Mark Dorsey
First Lamp Architecture
4915 S Rainier Ave S Ste 202
Seattle, WA 98118

Subject: Response letter for 2304-194 / DSR23-003 plan comments dated May 10th, 2023.

Summary of drawing changes

INTERIOR ELEVATIONS

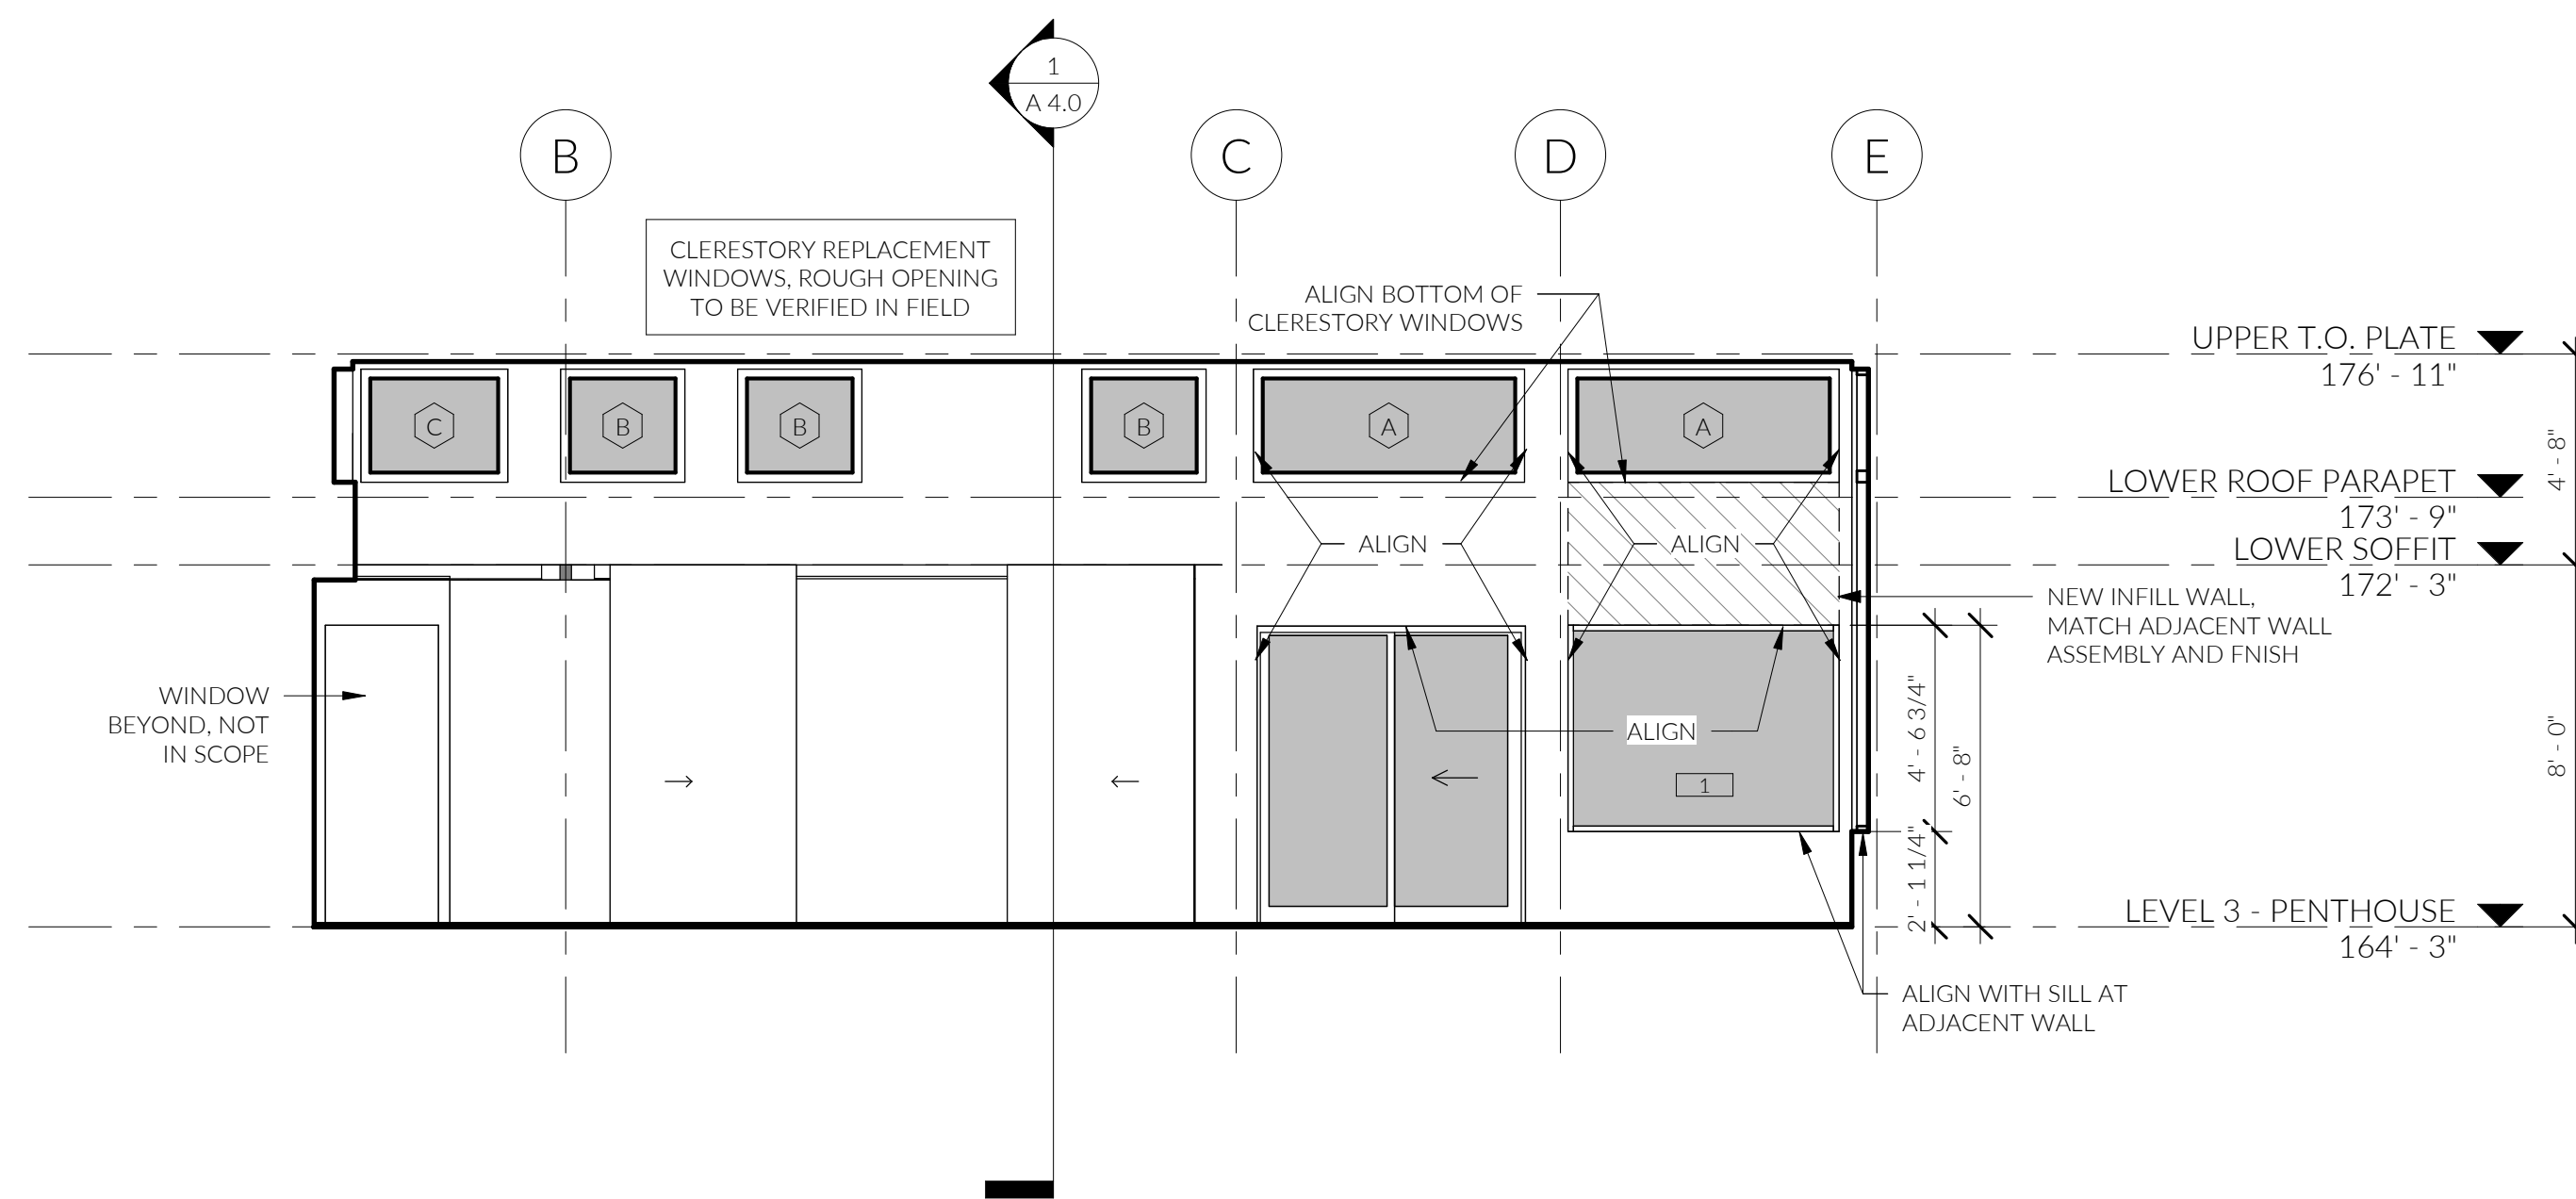
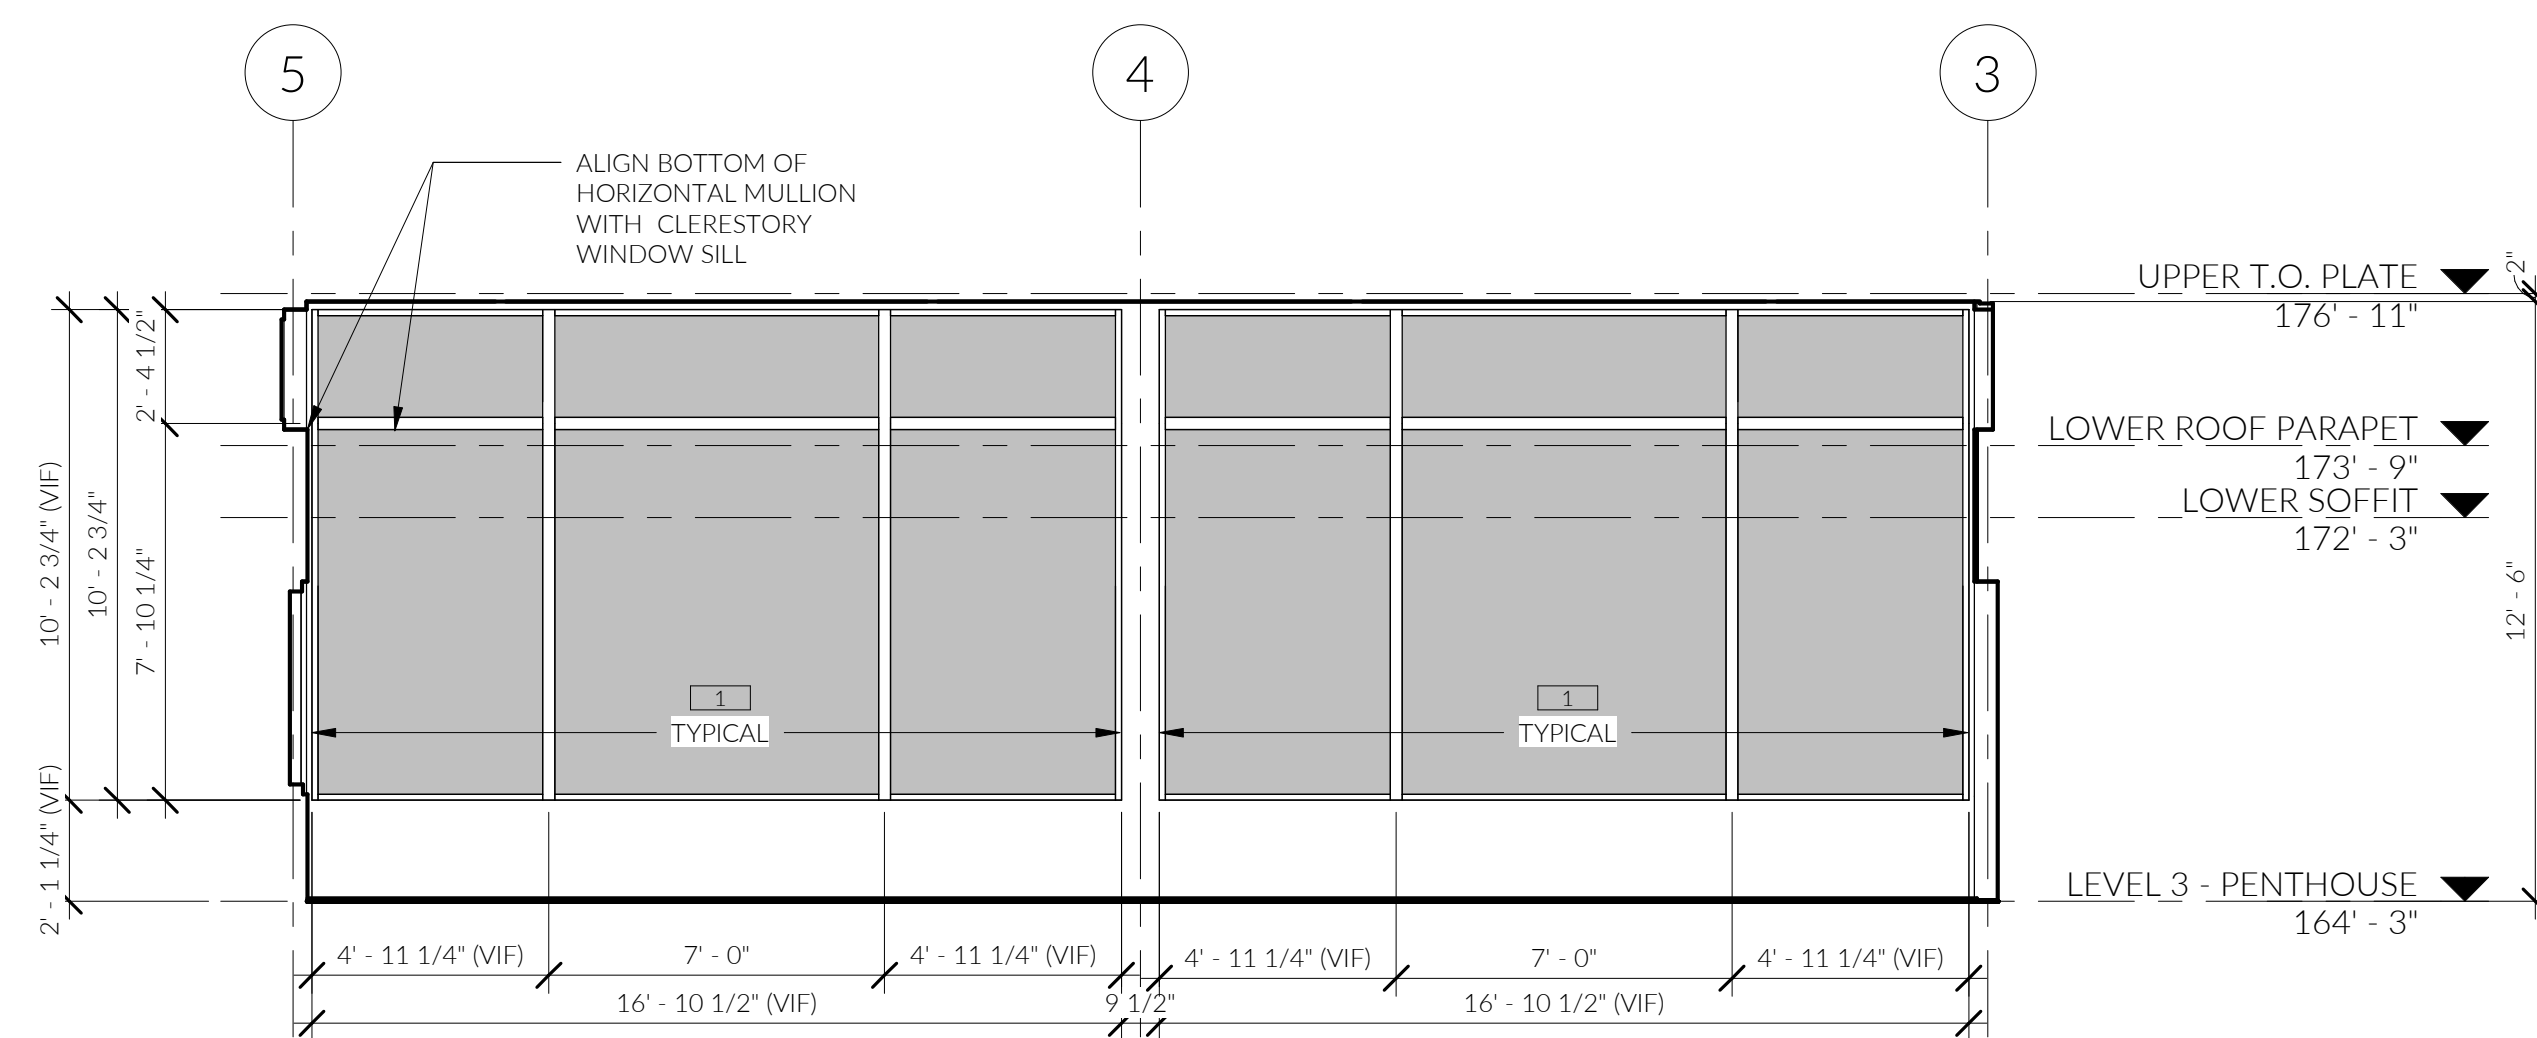
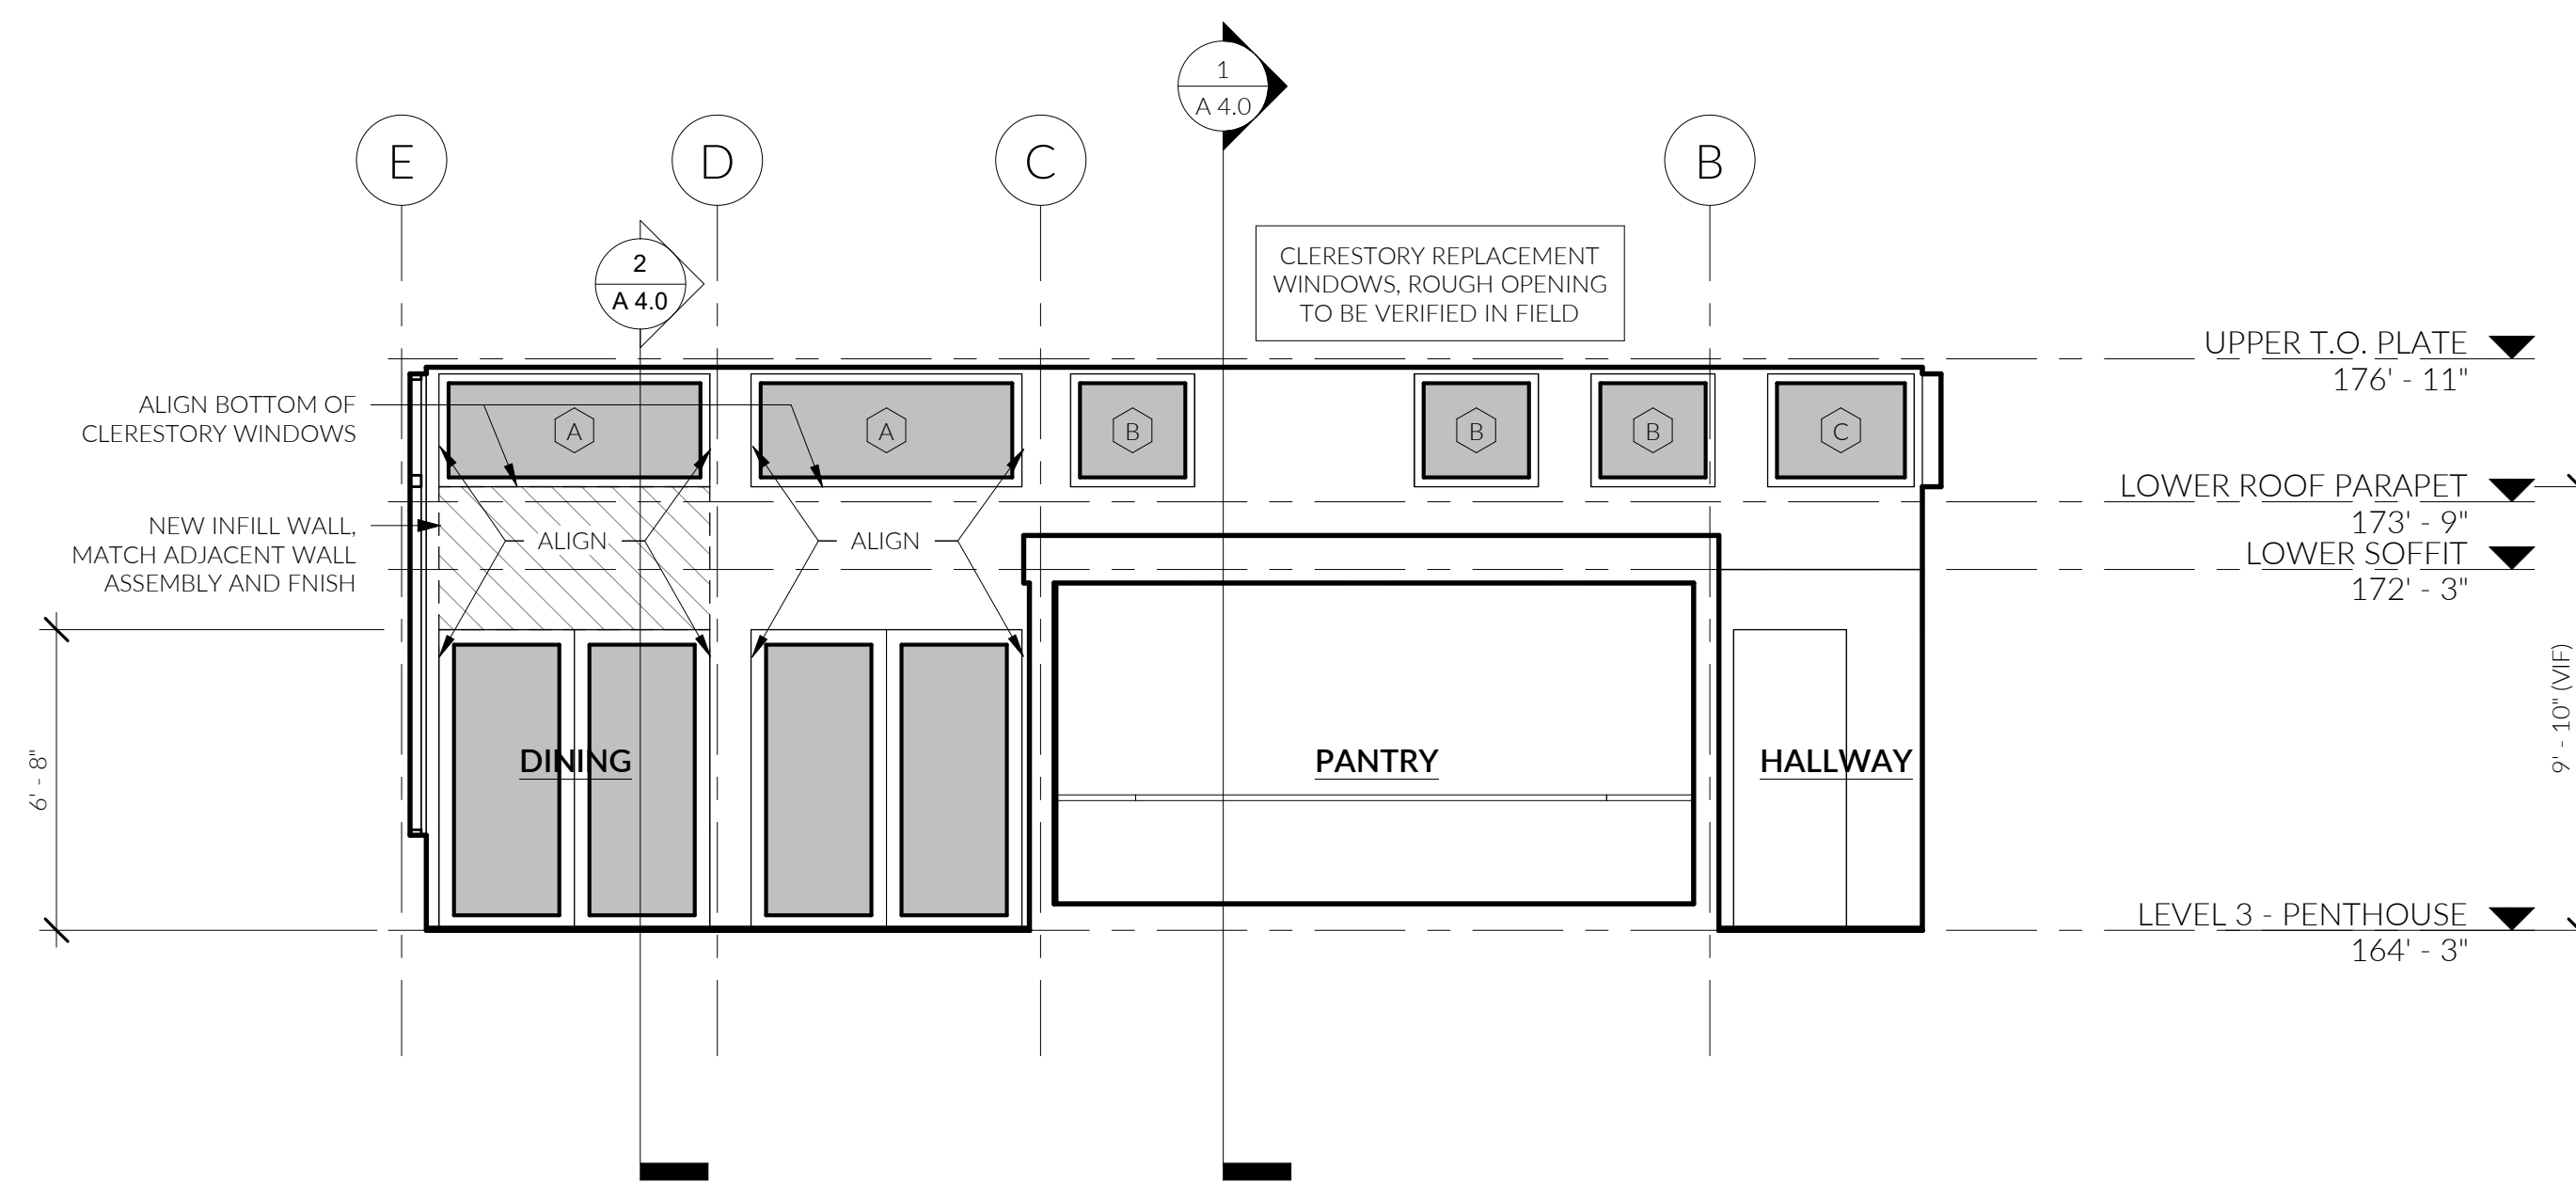
A6.0 - INTERIOR ELEVATIONS

Adjusted vertical mullion spacing at East facing windows between gridlines 3 & 5. Added horizontal mullion break to align with existing clerestory windows.
